Subject SSI-70610456 - Hunter Transmission Project - Advice on amendment report

Lake Macquarie City Council (LMCC) staff have reviewed the amendment report and provide the following comments.

Freemans Drive
BAL 10 set back

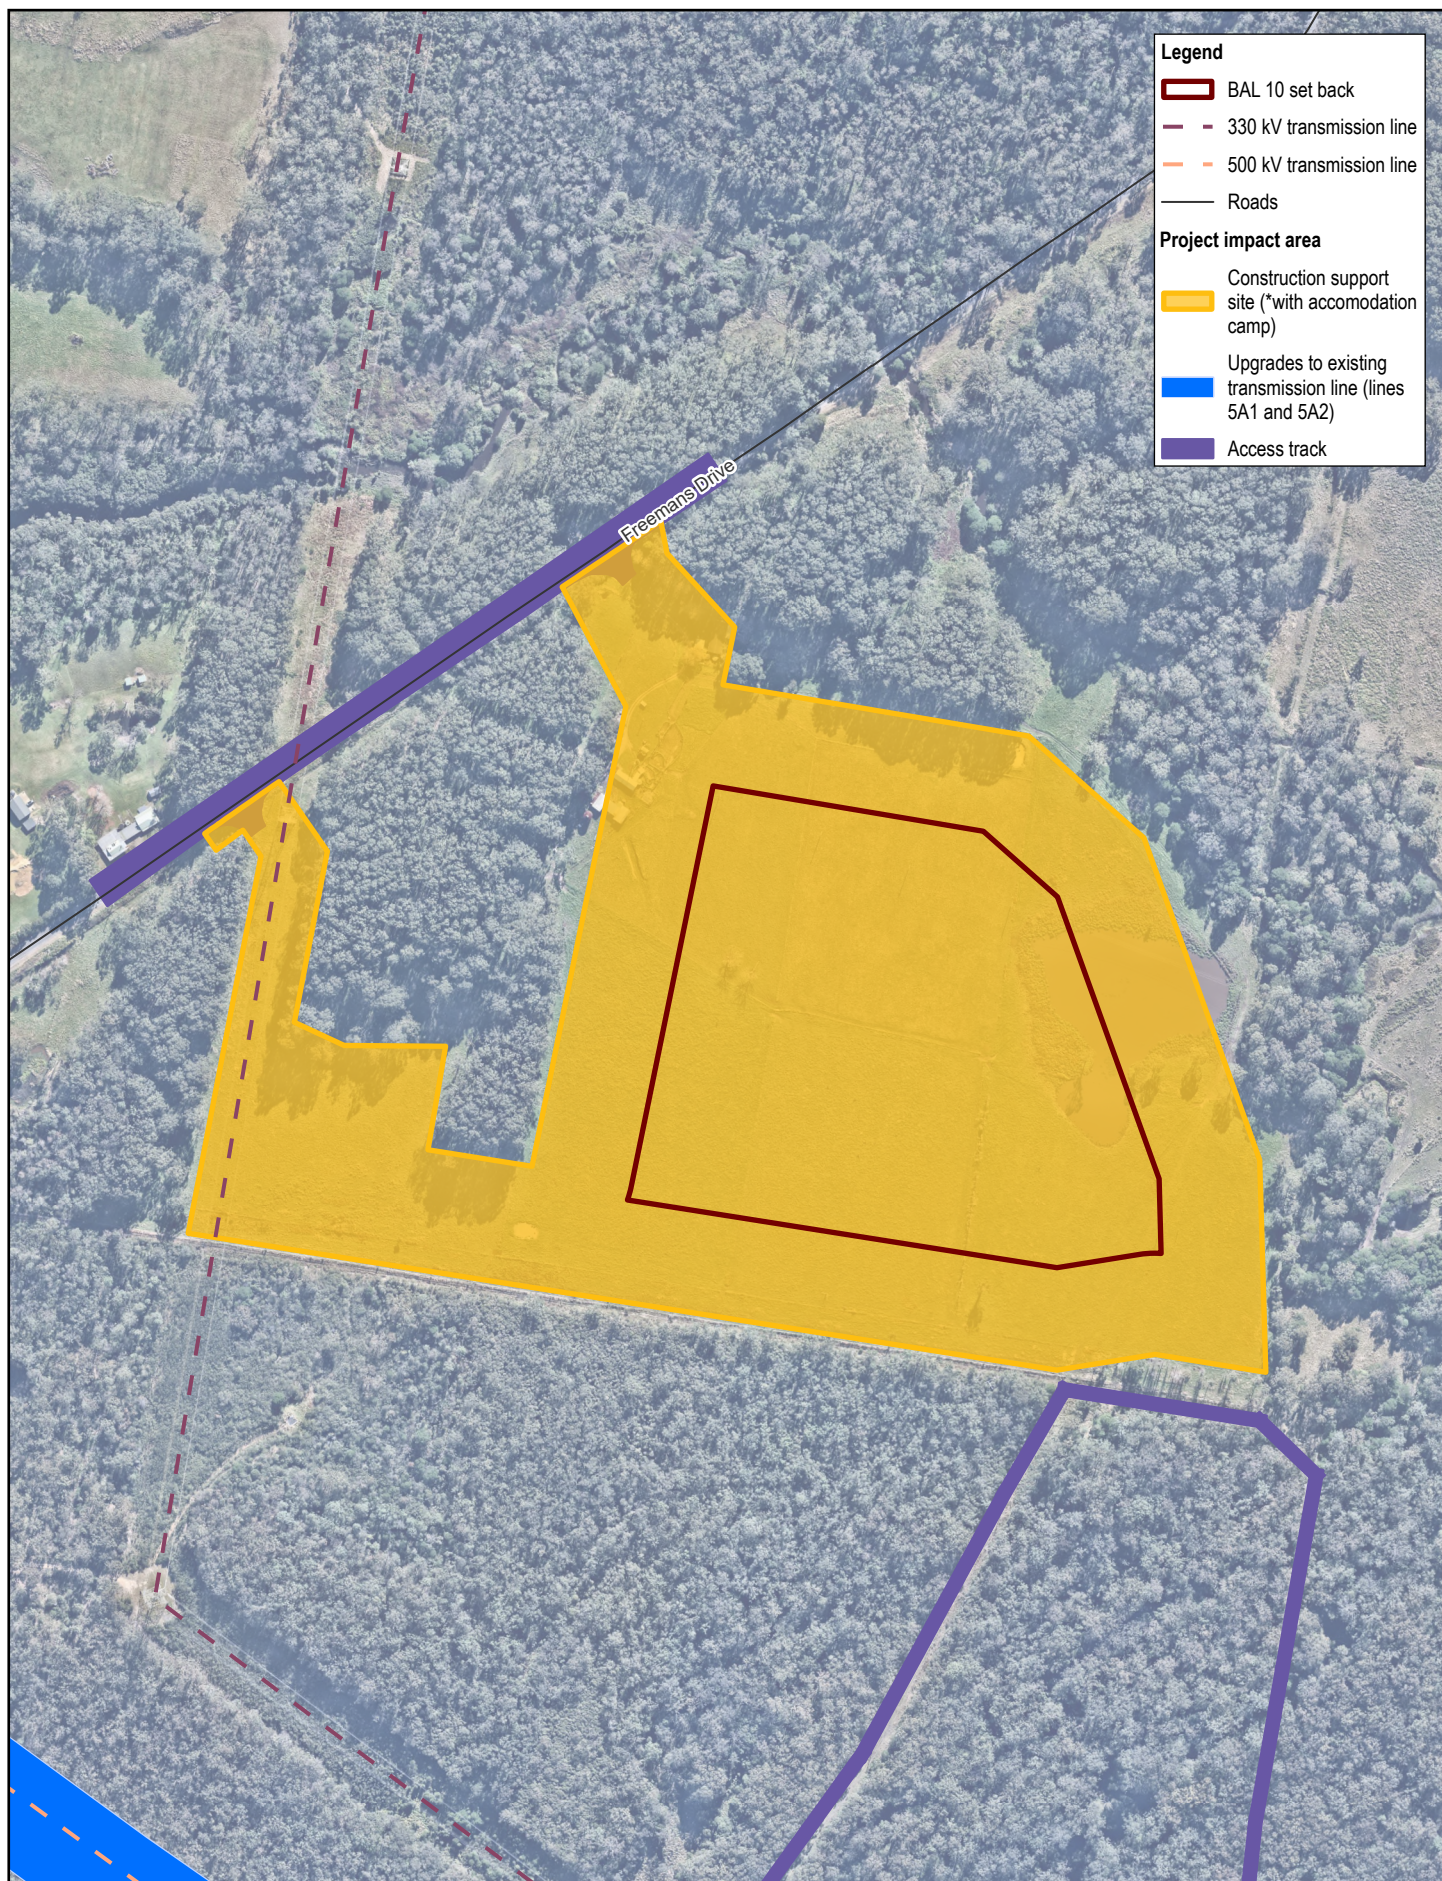
Subject to the site-based constraints being satisfied appropriately, as identified throughout this response, Council staff support the temporary workers' accommodation site at Freemans Drive. The use of the site for permanent housing is not supported, as the site location is zoned for rural and conservation use, which does not align with permanent housing of the proposed scale, and does not align with Council's objectives to support in-fill housing as a first priority.

Given the substantial investment required to prepare and operate the site, Council recommend the proponent investigate opportunities to reuse the built structures, particularly dwellings, to provide benefits to the Lake Macquarie community following completion of the project. This could include relocating the dwellings to other sites to assist with Council's strategic objectives for diverse and affordable housing.

- The proponent should investigate opportunities to reuse the built structures, particularly dwellings, to provide benefits to the Lake Macquarie community following completion of the project.
